Subject: AW/242/20/CLP - 29 Yeomans Acre

Further to my telephone call regarding the above application, we are currently looking to refuse the Lawful Development Certificate due to the height of the proposed eaves on the extension. As per Part d within Class A, the eaves on the proposed cannot exceed the height of the eaves on the existing building. You can see from the diagrams with the GPDO guidance that the eaves height is measured from NGL at the base of the external wall of the existing building to the upper surface of the roof slope.

PROPOSED ELEVATIONS

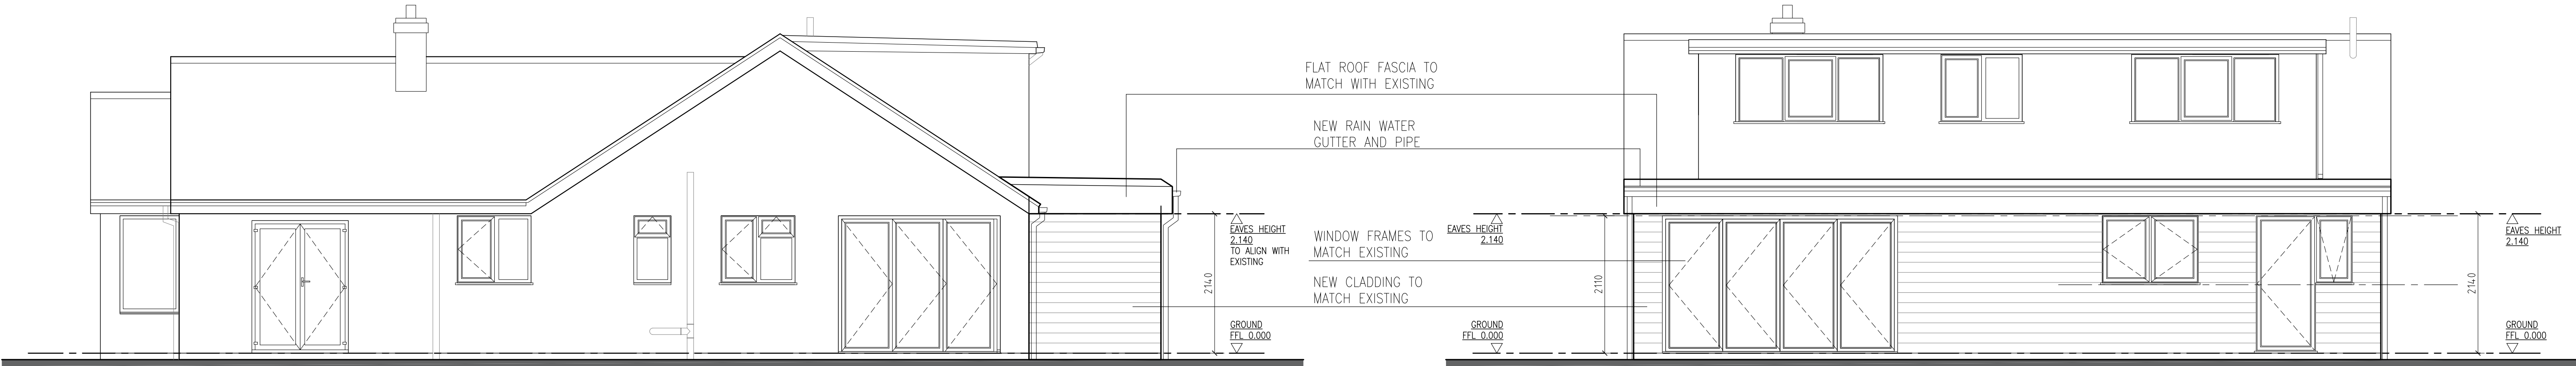
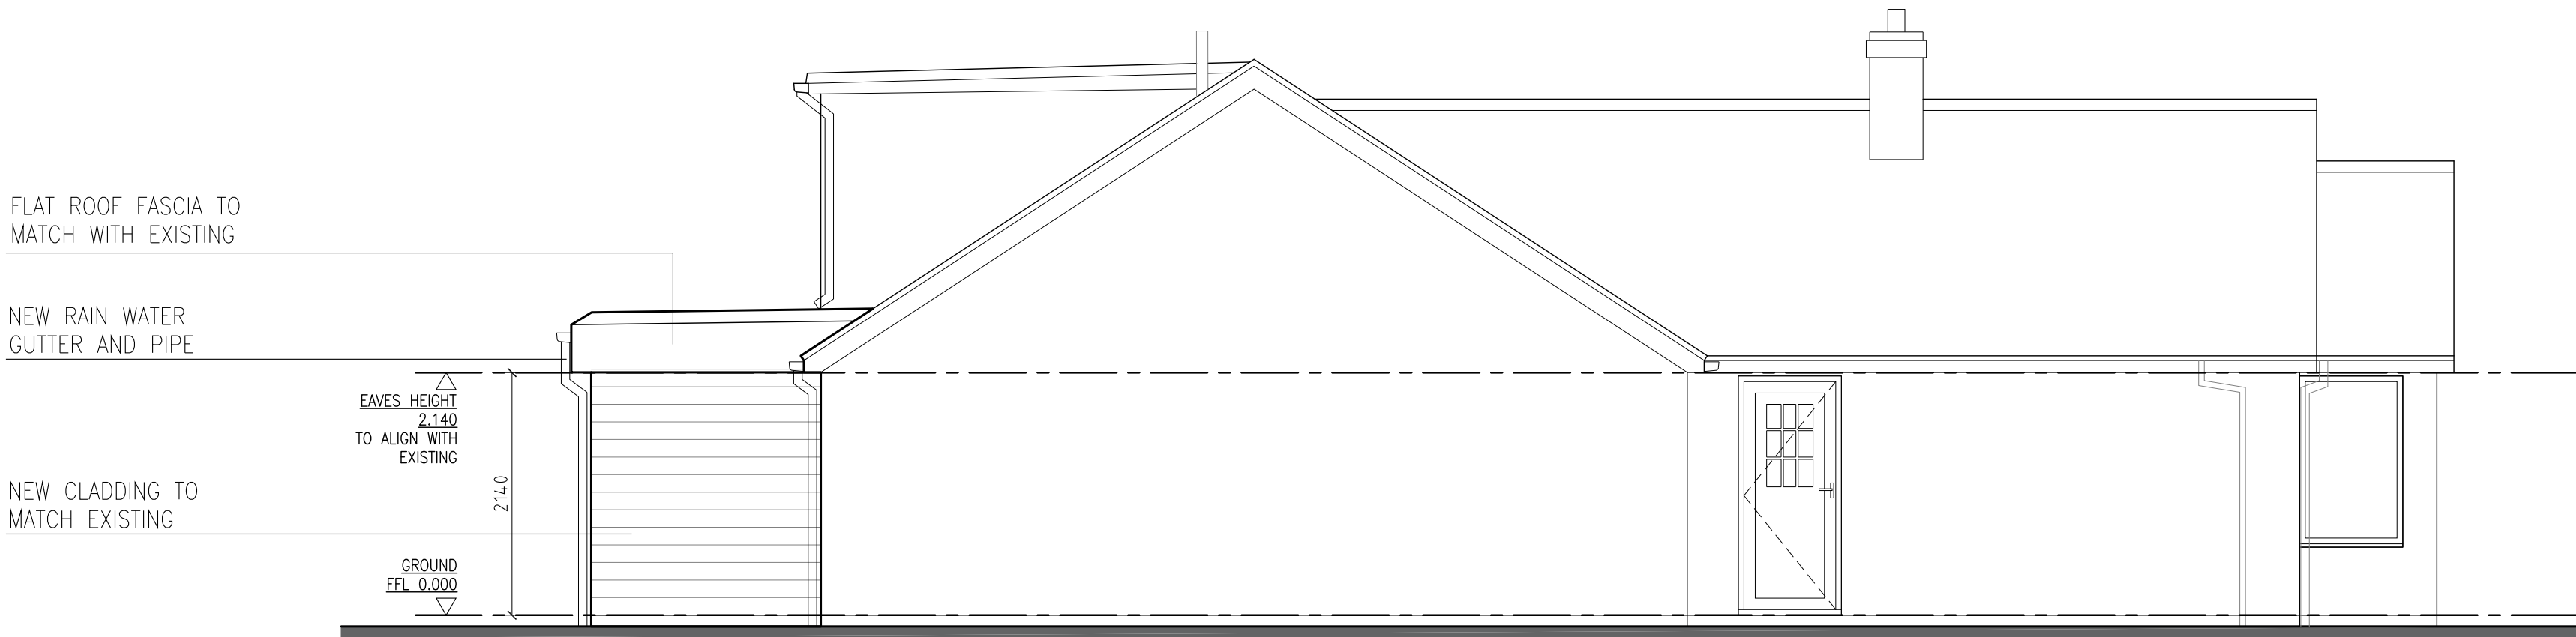
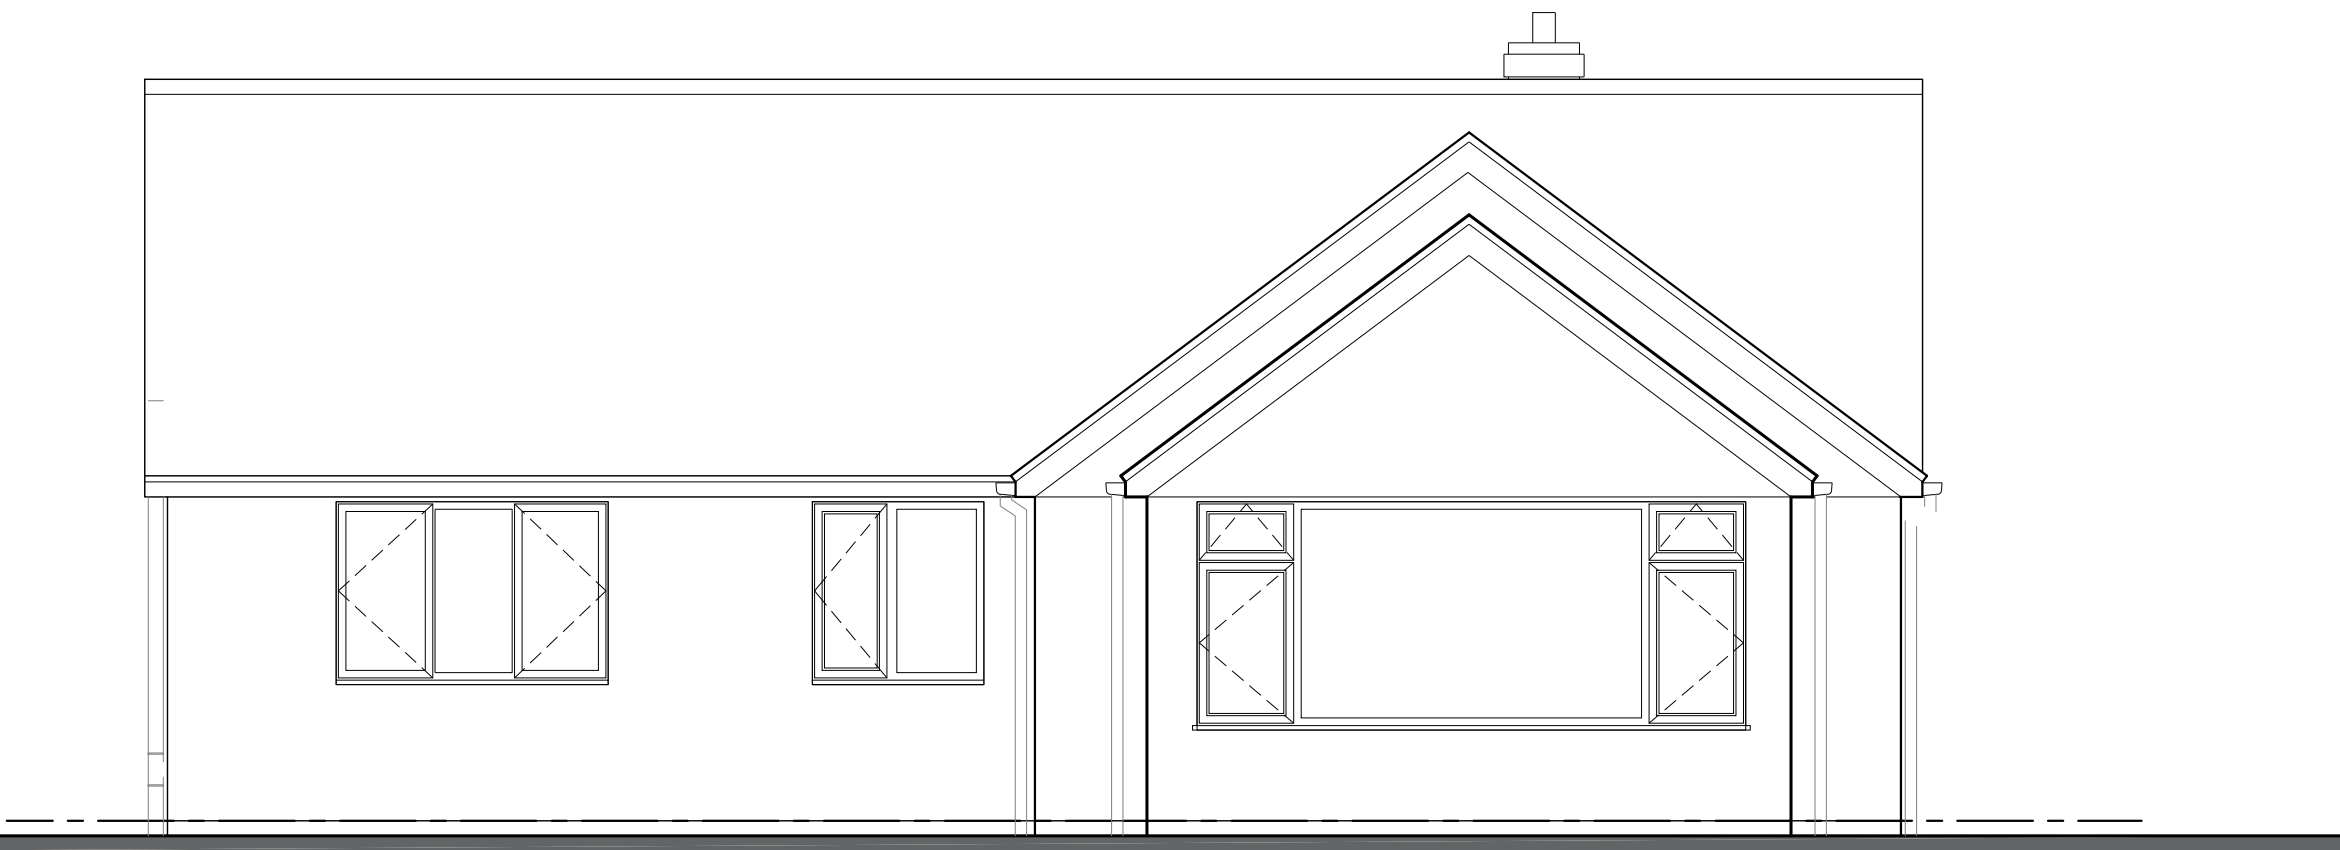
Therefore, I would be grateful if you could alter your proposed elevations to show this at which point I will be able to progress with the application.
